## Application for a Non-Material Amendment Following a Grant of Planning Permission

Amendments to the elevation of proposed pending Garage part of planning approved scheme - Amendments include - Doors, window positions amendments, Overhang of Roof to create rear canopy, increase in width of garage by less than 1 m to suit site boundary.

S/2131/16/FL

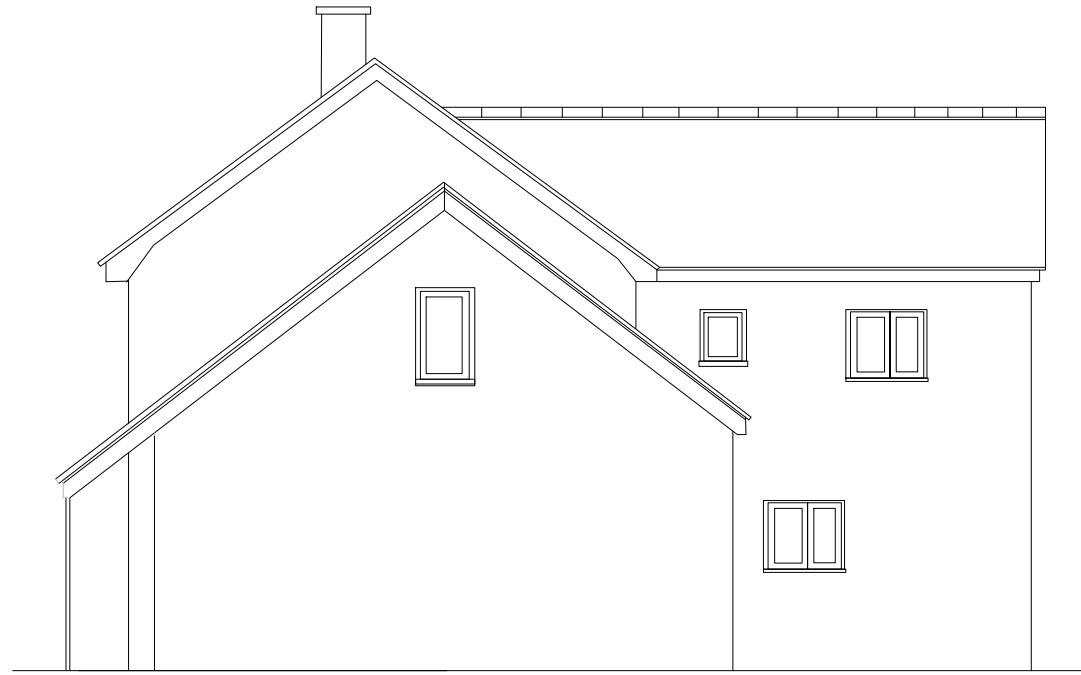
1. Rear elevation canopy overhang to store log wood, windows.
2. Front elevation changes as drawing to door, window positions and slightly larger width than approved plans (less than 1 m wide to suit onsite dimensions)
